Application number: 2022/93510	
What is the application for?:	Erection of detached dwelling with intergral garage
Address of the site or building:	Shiraz, 142, Upperthong Lane, Upperthong, Holmfirth, HD9 3UZ
Postcode:	HD9 3UZ

User comments

PROPOSED FLOOR PLANS

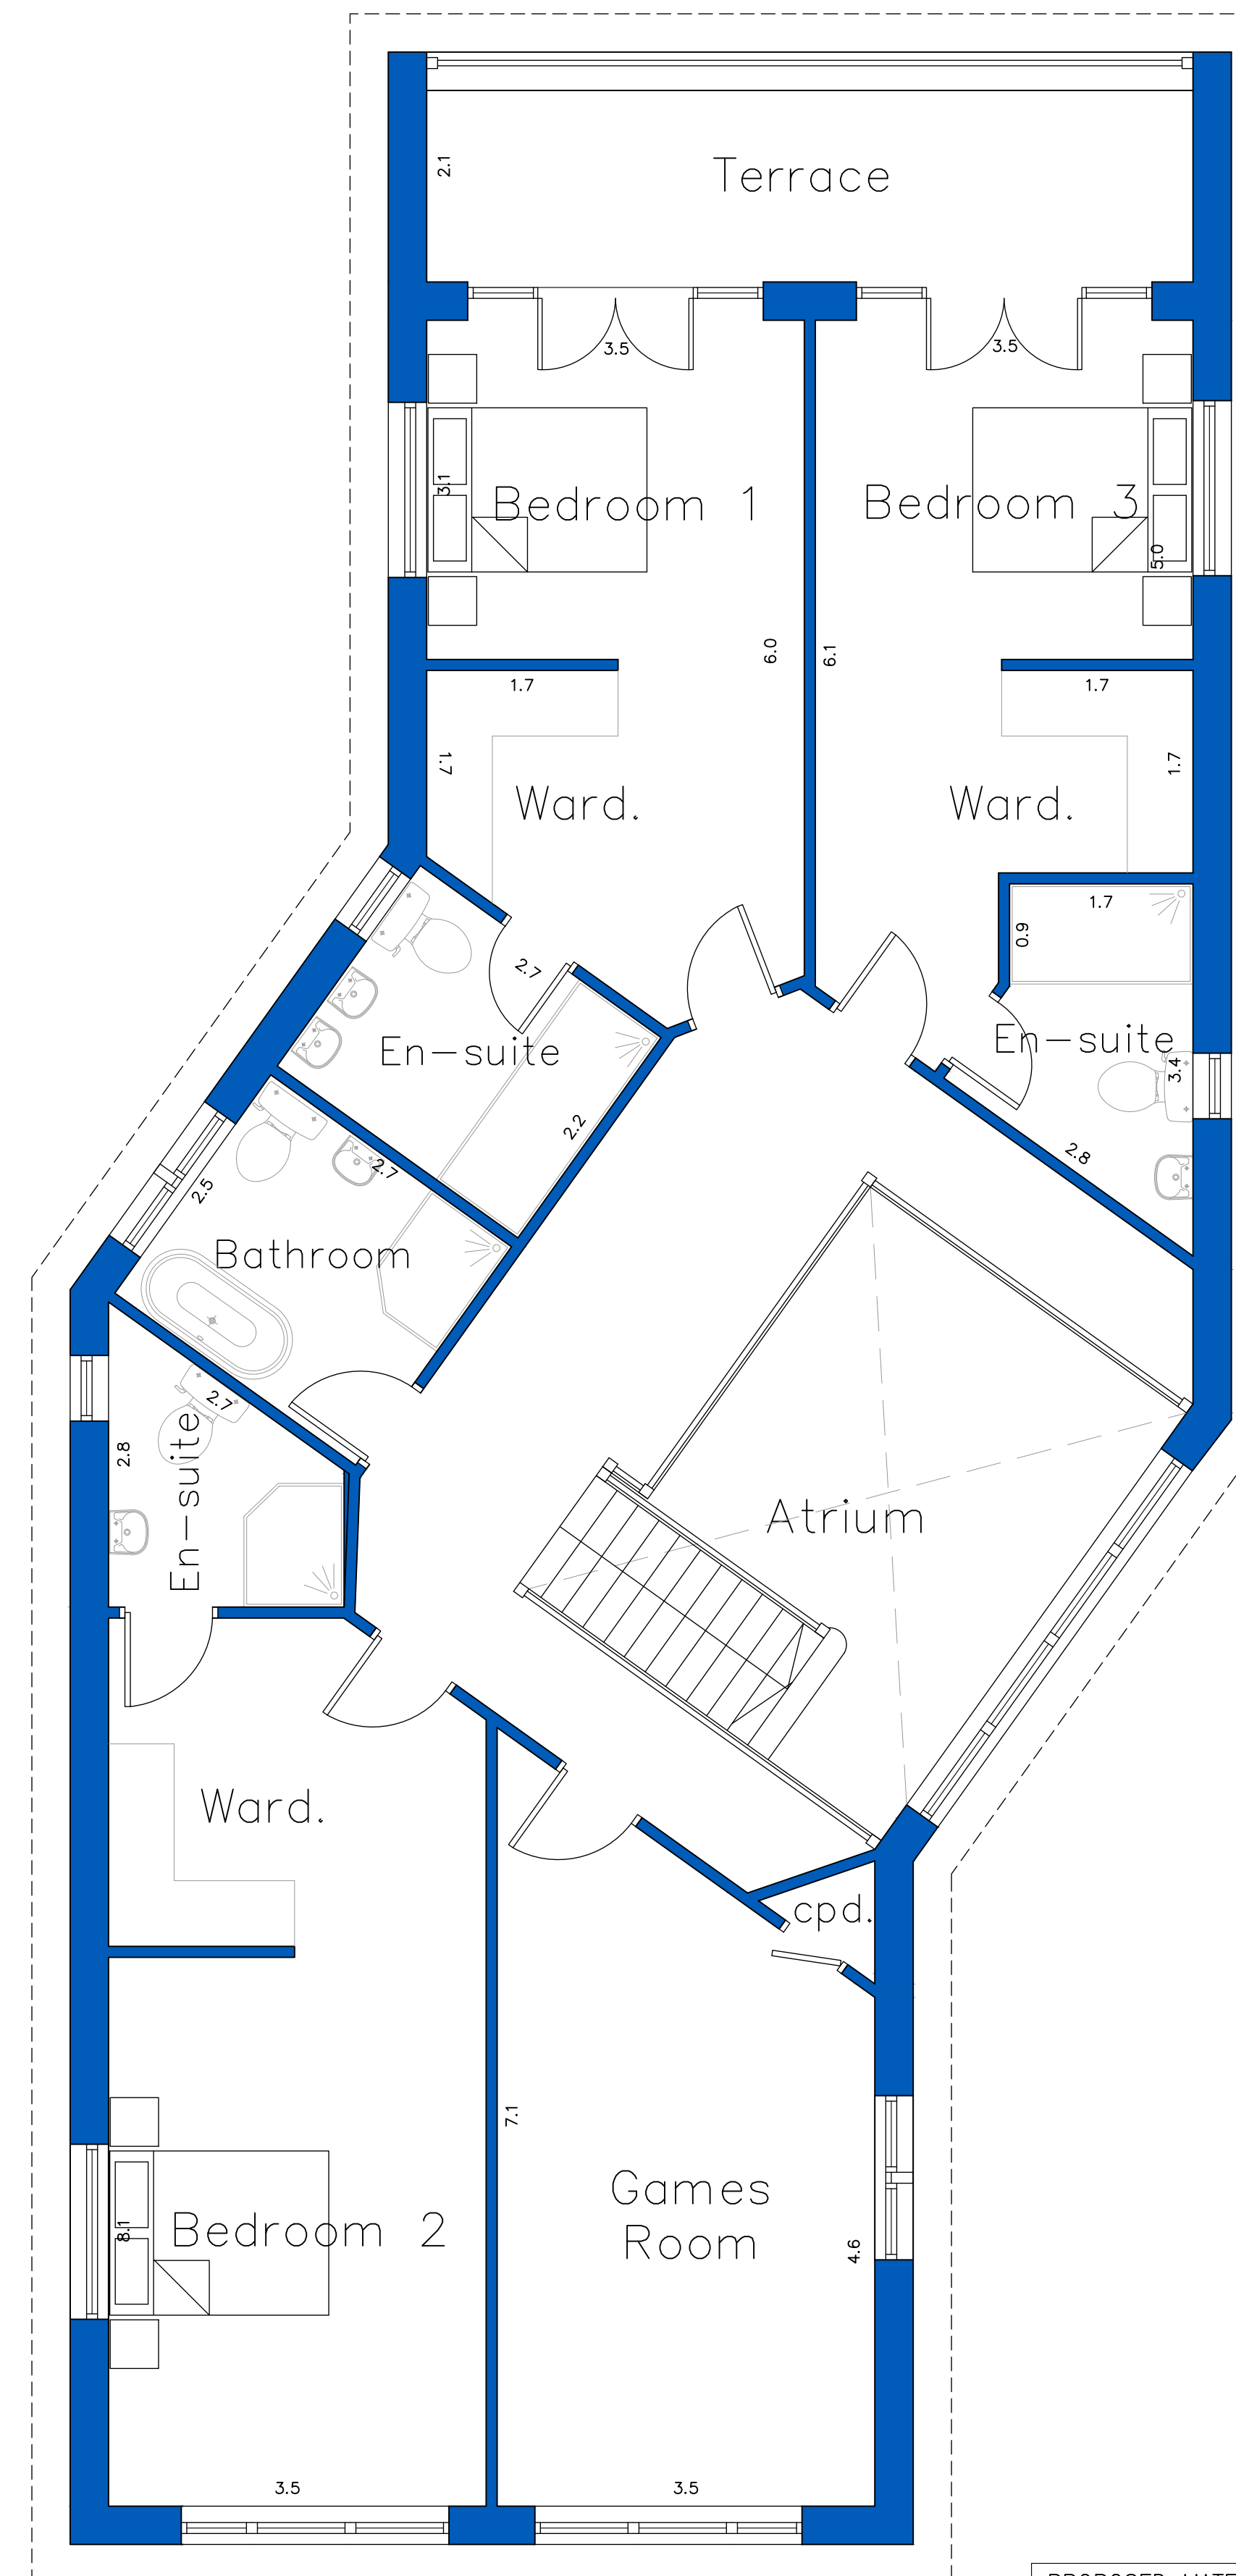
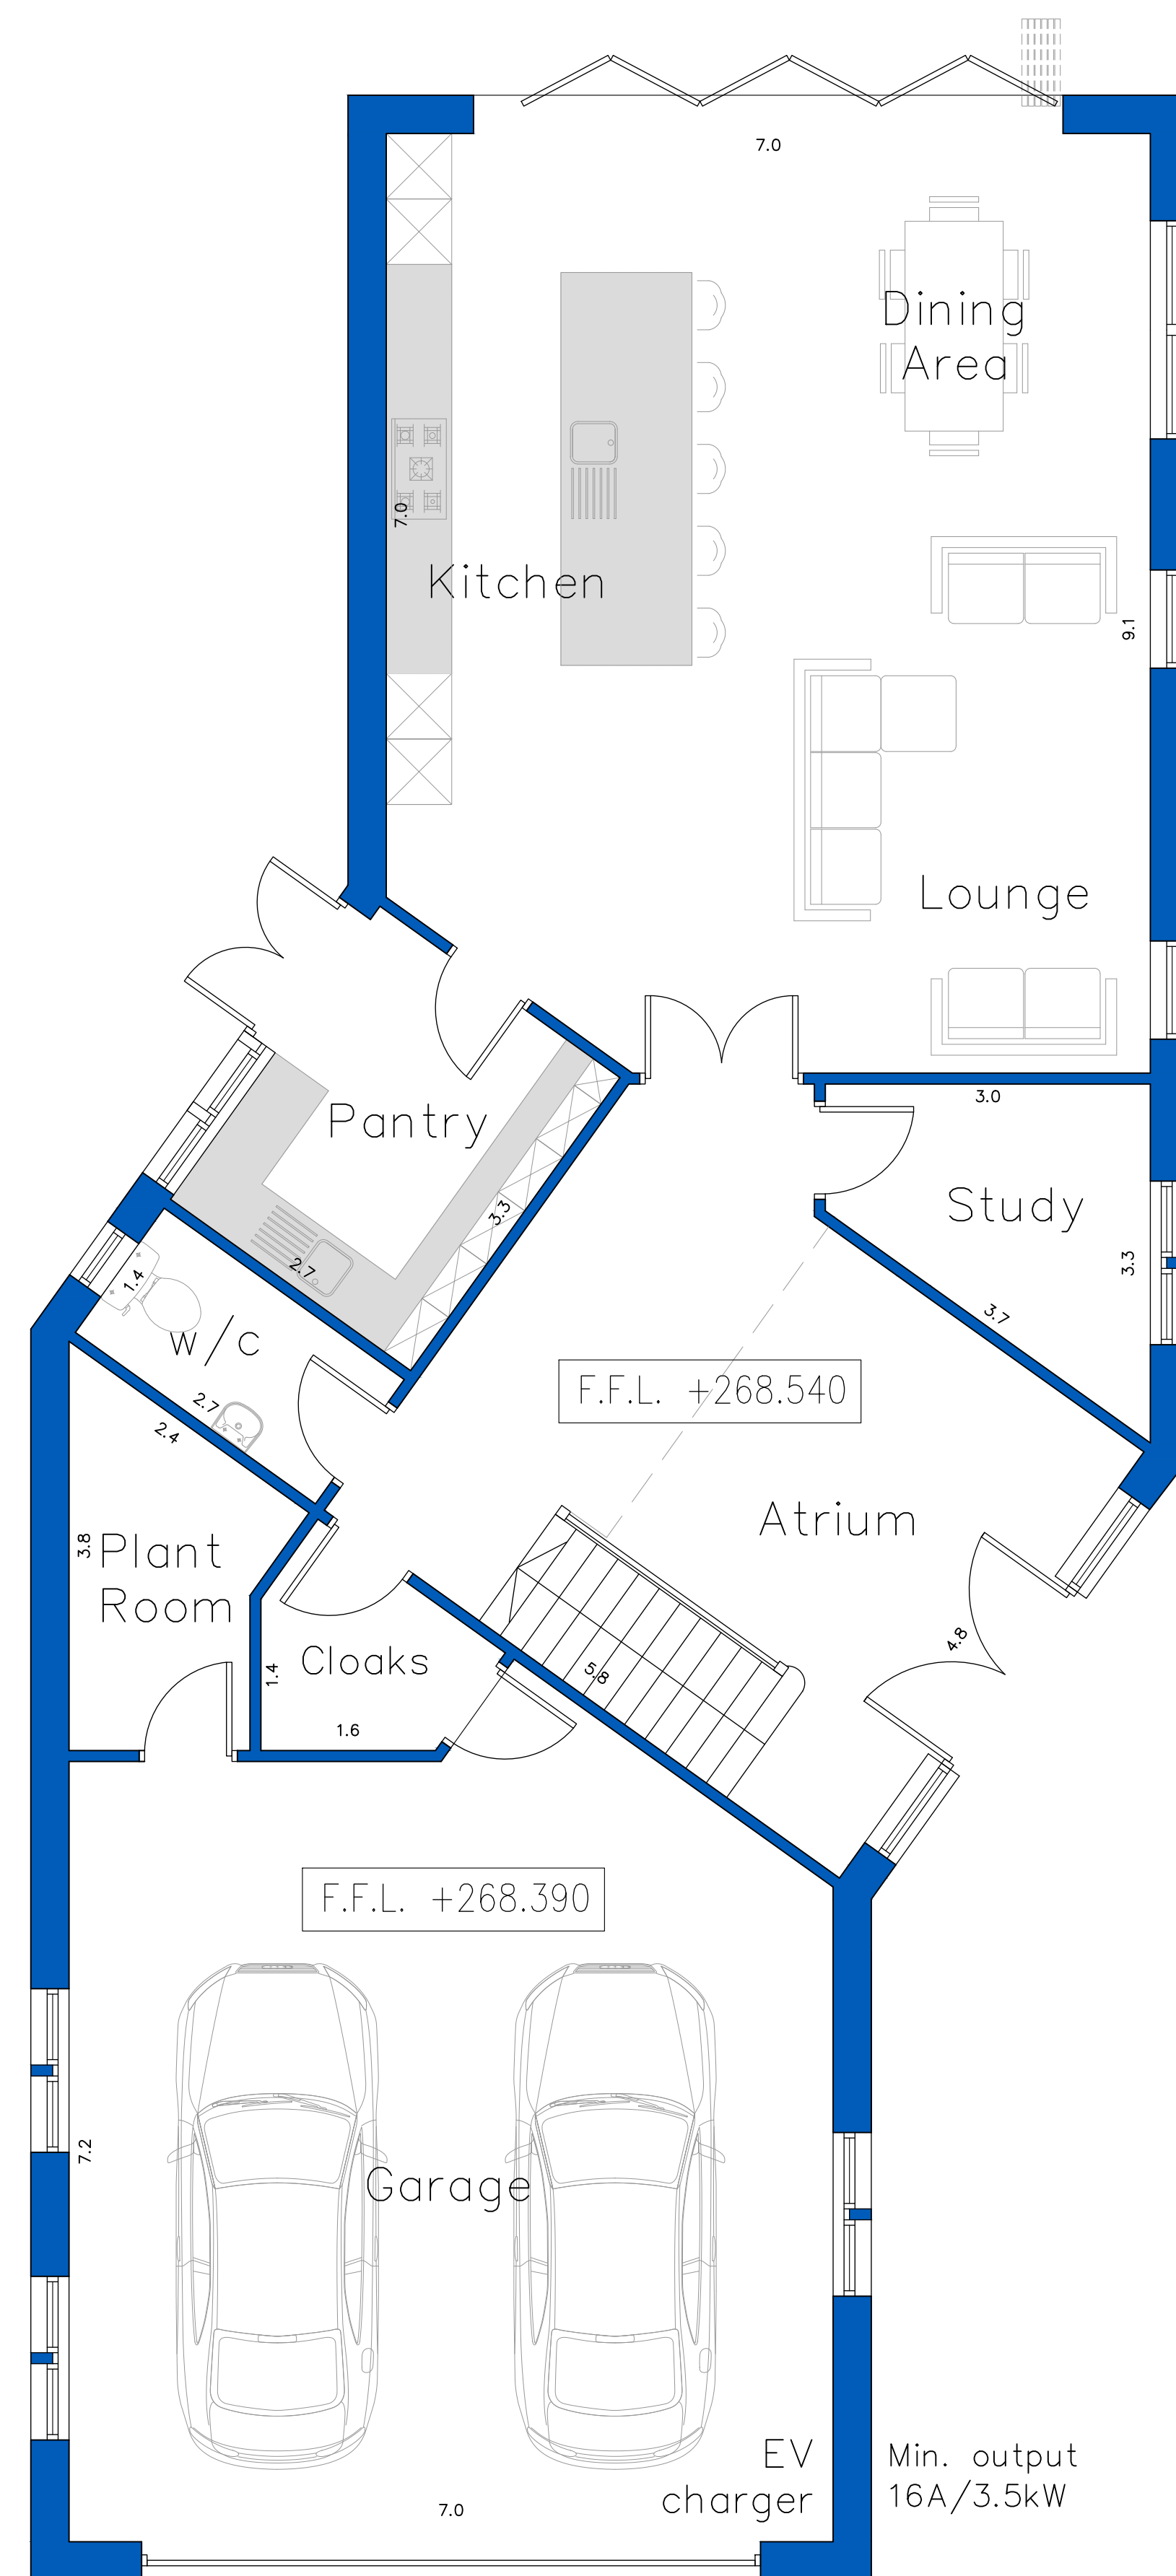
3. The current plans are an unusual design, with an unusual footprint, and include an atrium. Although modern design may be encouraged, this replacement house, sandwiched between bungalows, may stand out on the street- scene and not enhance it.
